2024/0191

65 Station Road, Worsbrough Dale, Barnsley, S70 4SZ

**Conversion of former commercial garage to 1no dwelling with associated works (Amended Description and Plans).**

PROPOSED
REAR ELEVATION
SCALE 1:100

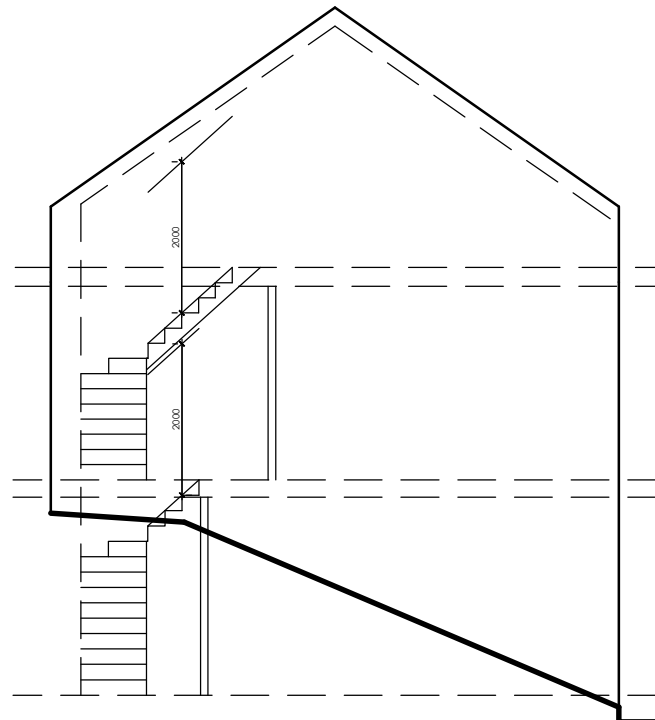
Conservation Officer – Concerns raised in relation to the flat roof rear dormer window and its impact on the historic character of the rear elevation.

The application property forms part of a collection of nineteenth-century buildings that contribute to a distinctive grouped local character. The Conservation Officer has acknowledged that the proposal would be an improvement from the scheme submitted at pre-application stage as the street-facing flat roof dormer window would be replaced by roof lights and the incongruous landscape orientated window would be replaced by three small vertically emphasised windows. However, concerns were raised regarding the proposed flat roof rear dormer window as this would deviate from other buildings in the group and could detract from the historic character of the rear elevation of the application property which has been determined to have the most character. It was suggested to the applicant that conservation specific roof lights or pitched roof dormer windows could be more acceptable alternatives. However, the applicant declined to implement any change to the rear dormer window due to the loss of additional space and existing examples within the locality.

Whilst the applicant has declined to implement the suggested changes of the Conservation Officer, the proposed rear dormer window would adopt a relatively modest scale, would be set back from the eaves and set in from the gable elevations of the application property, would be constructed of materials that would match or be similar in appearance to the proposed slate affect roofing materials, and would maintain vertical alignment with existing openings below, in accordance with the House Extensions and Other Domestic Alterations SPD. Moreover, the proposal would incorporate a modest rise in roof height that would not significantly alter the existing street scene ridge line and would maintain the style, pitch and detailing of the existing roof. Additionally, the extended part of the building would be constructed of stone and only minor alterations would occur to its north, west and south elevations, comprising the replacement of an existing garage door with small vertically emphasised windows and replacement doors and windows to existing openings. Furthermore, the applicant has confirmed that a historic engraved stone above the rear elevation doorway would be retained.

BLOCK PLAN
SCALE 1:500

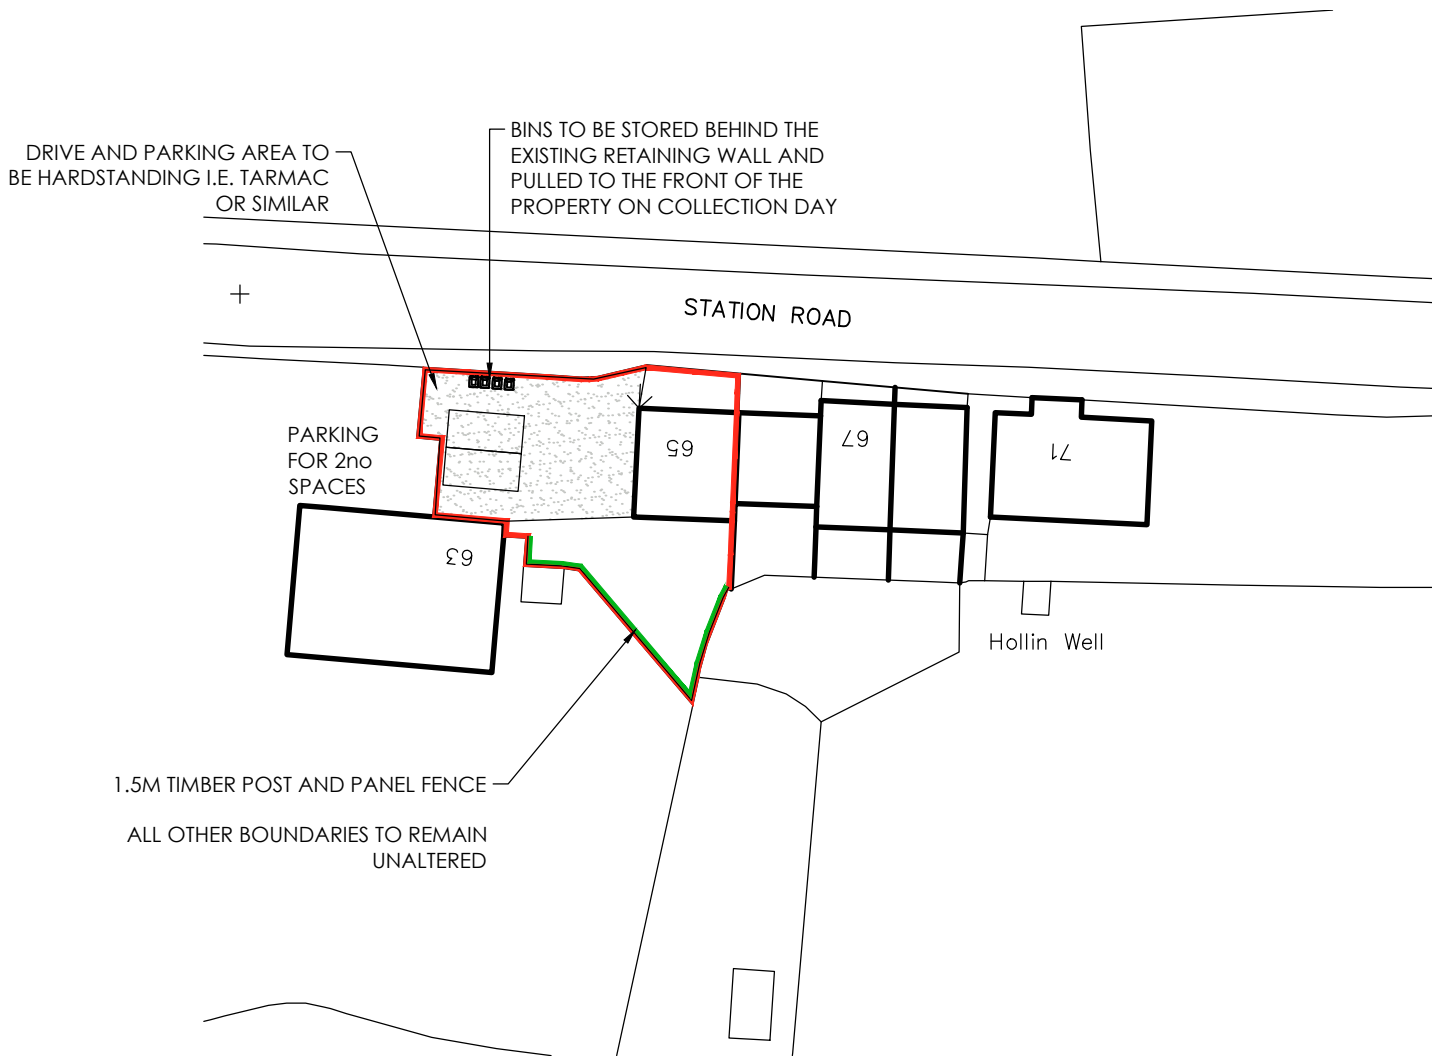
Highways DC – Concerns raised in relation to the existing access as it would be at a very acute angle and some manoeuvres are unlikely to be achieved without mounting the footway on the opposite side the road or turning within the carriageway.

The proposal shows that an existing retaining wall to the front of 63 Station Road would be raised by approximately 0.6 metres which would level the ground in this area to facilitate proposed off-street parking. A six-metre-high wall would not be erected to the front of the neighbouring property. During the application process the applicant included the erection of a fence to address earlier concerns raised in relation to loss of privacy, and whilst it is acknowledged that the proposed fence could contribute to some overshadowing and loss of outlook of a habitable room window (bedroom), the proposed fence would be set back from the edge of the retaining wall and a planting buffer would be incorporated which could lessen the extent of any potential impact. In any case, the erection, construction, maintenance, improvement or alteration of a gate, fence, wall or other means of enclosure not erected or constructed adjacent to a highway used by vehicular traffic is permitted development provided that it would not exceed 2 metres above ground level. The proposed fence could therefore be implemented without planning permission and as such, any potential impact that could arise could not be controlled by the local planning authority.

Highways DC have raised concerns in relation to the existing access and have stated that it would be at a very acute angle which would mean that some manoeuvres are unlikely to be achieved without mounting the footway on the opposite side the road or turning within the carriageway, both of which would be prejudicial to highway safety. It was stated that the gradient of the drive and parking area must not exceed 1:12 and that pedestrian visibility splays of 2m x 2m must be provided at the proposed access point.

During the application process, the applicant amended the proposal to introduce low-level planting to the edge of an existing retaining wall to the front of 63 Station Road to act as a buffer between the neighbouring property and a proposed 1.5 metres-high fence. It would also set the fence back from the edge of the retaining wall. An existing area to the rear of the application property would be retained as a garden.

Planning permission is required for the creation of a new access off a classified road. However, the proposal relates to the use of an existing access and therefore planning permission is not required. As such, vehicle manoeuvres, turning and pedestrian splays cannot be controlled. Moreover, hard surfaces incidental to the enjoyment of a dwellinghouse can be implemented as permitted development provided that either the hard surface is made of porous materials, or provision is made to direct run-off water from the hard surface to a permeable or porous area or surface within the curtilage of the dwellinghouse. In this instance, the proposed drive and parking area would be formed of hardstanding such as tarmac or similar and therefore does not require planning permission. As such, the gradient of the drive and parking area cannot be controlled.

PROPOSED FENCE

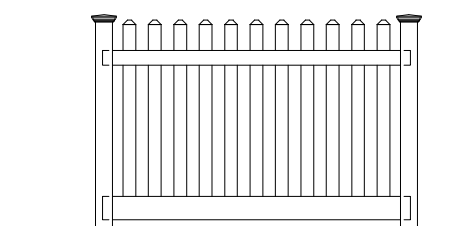
- A historic marker above the rear doorway should be retained.
- Boundary fencing should be 6m to maintain privacy.
- Building of a 6-metre wall with additional 1.5 metre fence to front of 63 Station Road will restrict light to bedroom window and the sense of being blocked in.
- Clarification regarding the location of waste and recycling storage.
- Disruption and impact to privacy due to the proximity of proposed vehicle parking to the front bedroom and bathroom window of 63 Station Road.
- Increased overlooking of rear garden from windows within the heightened roof.

The following concerns were raised in relation to residential amenity: the building of a 6-metre-high wall with an additional 1.5-metre-high fence to the front of 63 Station Road will restrict light to a bedroom and bathroom window and will result in a sense of being blocked in; loss of privacy because of the proximity of the proposed vehicle parking to the front of a bedroom and bathroom window to 63 Station Road; and overlooking of the rear garden of 63 Station Road from the windows within the heightened roof.

The proposed dormer window to the rear of the application property would face towards a relatively small area of the neighbouring curtilage to the west side of 63 Station Road. The boundary treatment in this location is formed by several trees and vegetation within the curtilage of the neighbouring property that would likely continue to provide an acceptable level of screening which could lessen the extent of any potential impact. Moreover, the proposal shows that a new 1.5-metre-high fence would be erected along the southern boundaries of the application site that could offer further mitigation. A taller fence of up to 2-metres-high could be erected under permitted development if required.
